1 Introduction

JMT Consulting has been commissioned by the University of New South Wales (UNSW) to prepare this document in response to the issues raised in by government agencies, community organisation groups and the public during the public exhibition of the proposed UNSW Health Translation Hub (HTH) State Significant Development (**SSD**) application (SSD-10822510).

This document has been prepared to respond to the transport related issues raised by Transport for NSW and Randwick City Council as reproduced on the following pages.

Concept design road safety audit

1
DA1001
UNSW Campus Connection_Ground Floor Plan
SCALE: 1 : 100

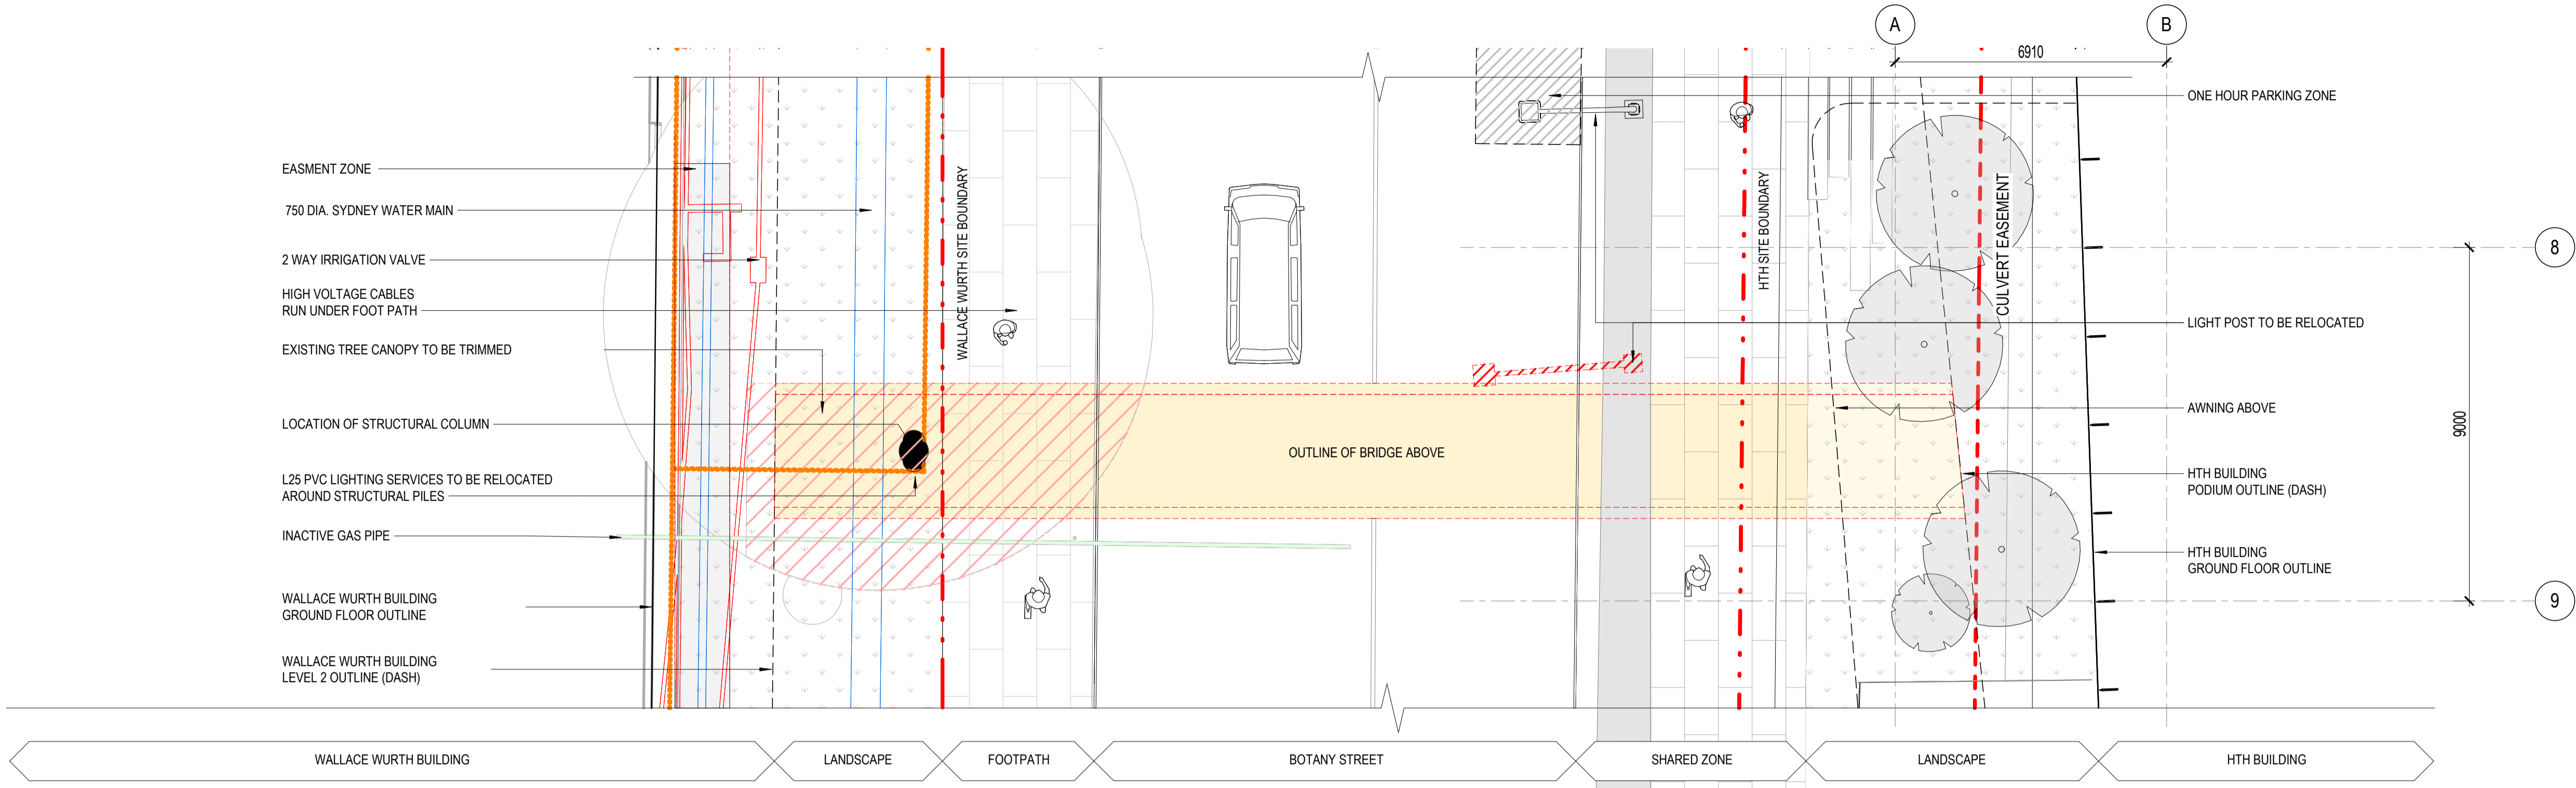
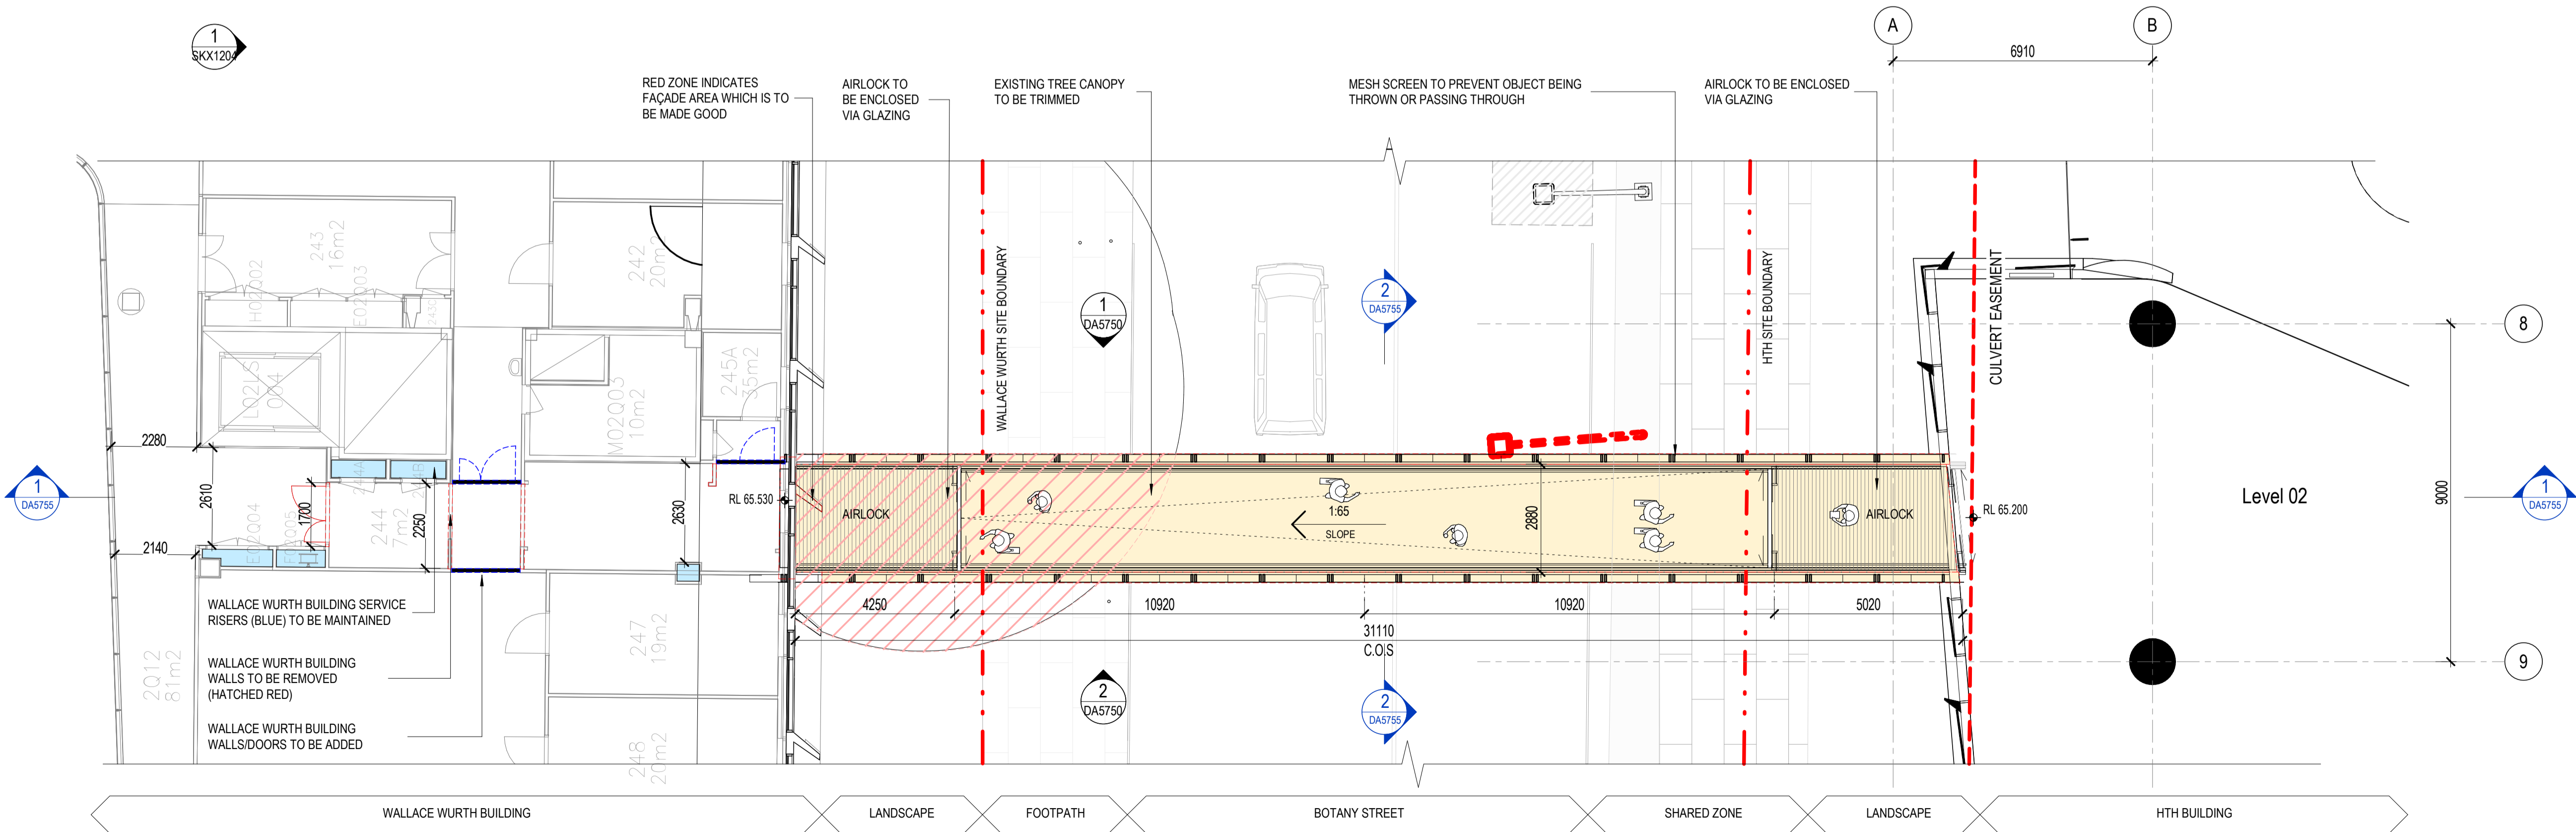
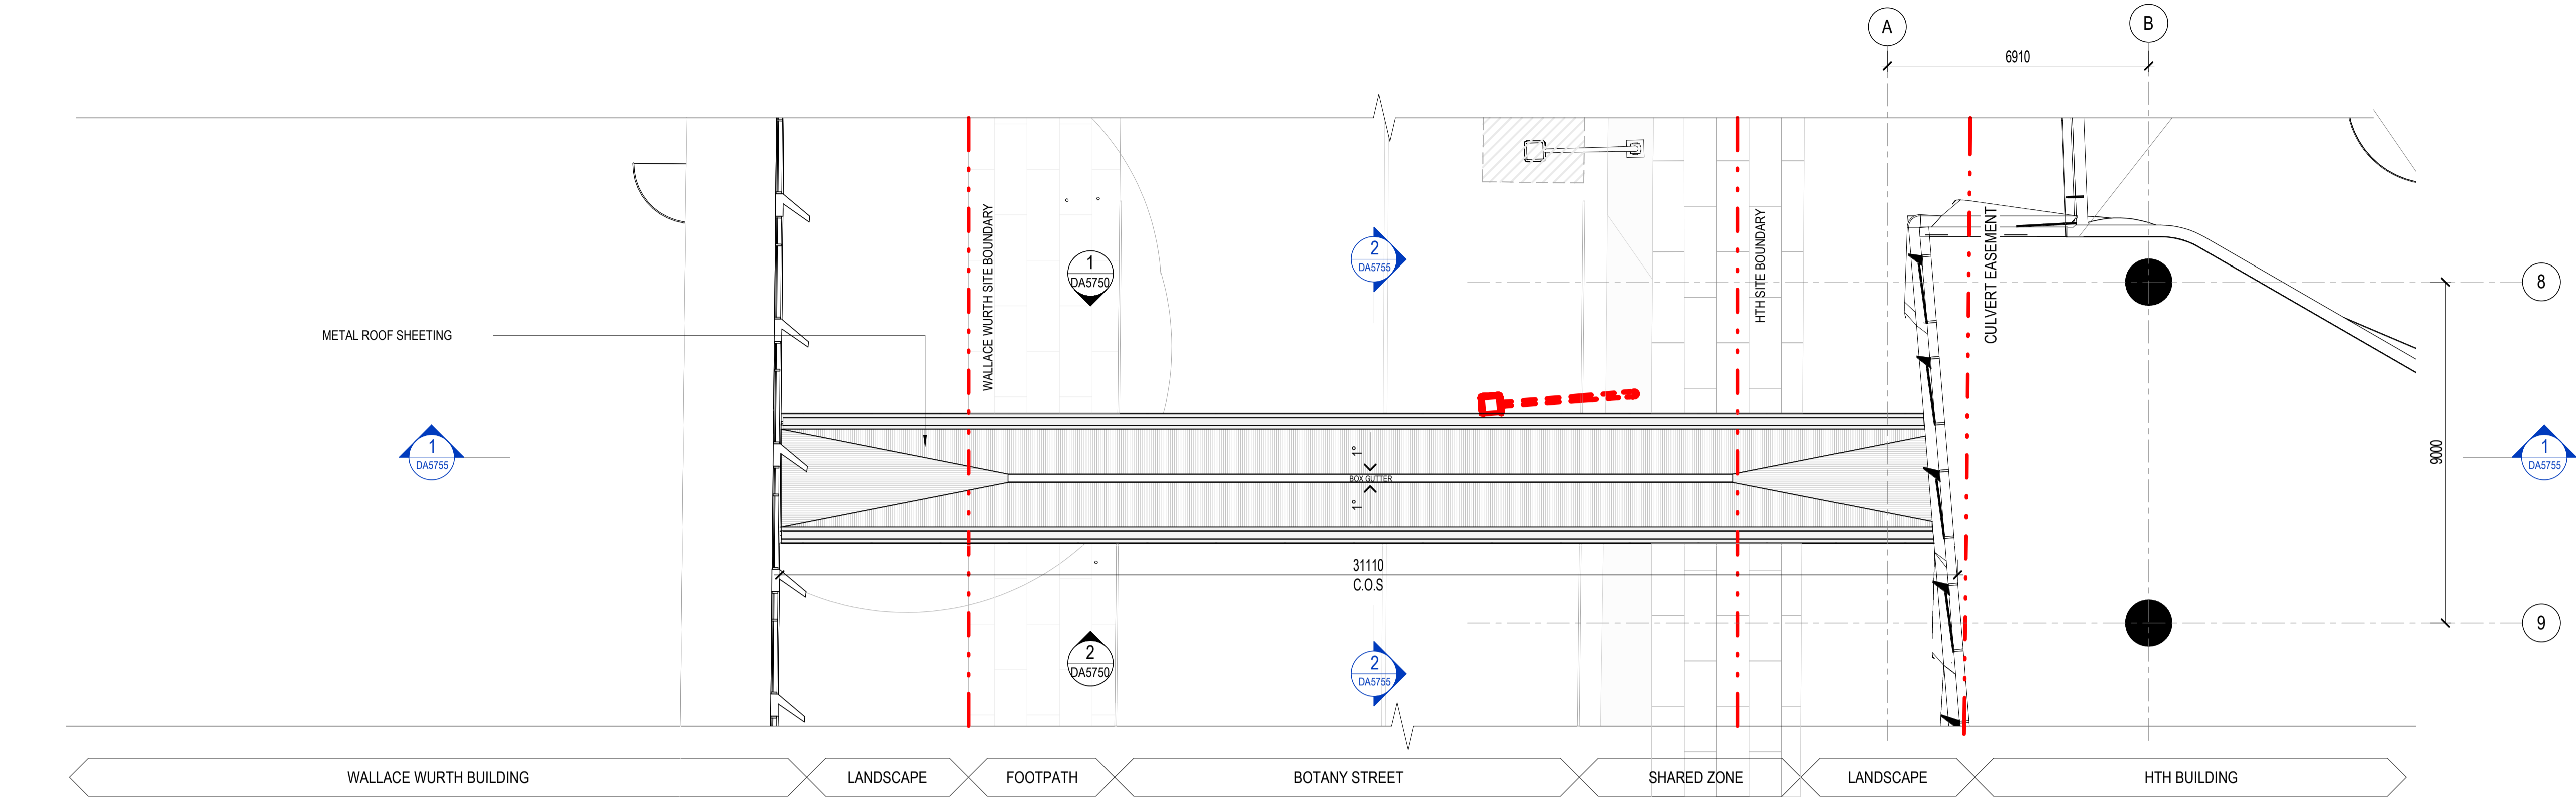
Ref	Location	Road safety audit finding	Priority
1	UNSW Campus Connection bridge.	<p>The design includes a pedestrian bridge over Botany Street to link the HTH to the Wallace Wurth Building. This appears to be exclusively for patrons of the HTH and the Wallace Wurth Building, to enable these pedestrians to cross between these buildings without using the roadway. The audit team questions why this bridge cannot be made more accessible to other members of the public. This also includes other patrons of both sites that may not come from the required floors of the building, eg. pedestrians in the UNSW Plaza area, from the bus zone or from the ground level facilities in the HTH.</p> <p>A more publicly accessible bridge would offer a grade separated road crossing facility that eliminates the <i>vehicle-pedestrian</i> crash conflict. The alternative for ground-level pedestrians is to walk 60m north to the signalised crossing at the High Street intersection, or 100m south to the signalised intersection at the vehicle access to HTH. As both of these signalised crossing points are considerable distances in each direction, the audit team envisages a high degree of non-compliance, with pedestrians likely to jaywalk between the two sides of Botany Street in uncontrolled midblock locations.</p>  <p>Above: The design includes a bridge connection between the HTH and the Wallace Wurth Building. However, this does not appear to allow for public access. Rather, it appears to be exclusively for patrons of the HTH and Wallace Wurth Building. This is a missed opportunity to improve safety and amenity for all pedestrians.</p>	Medium
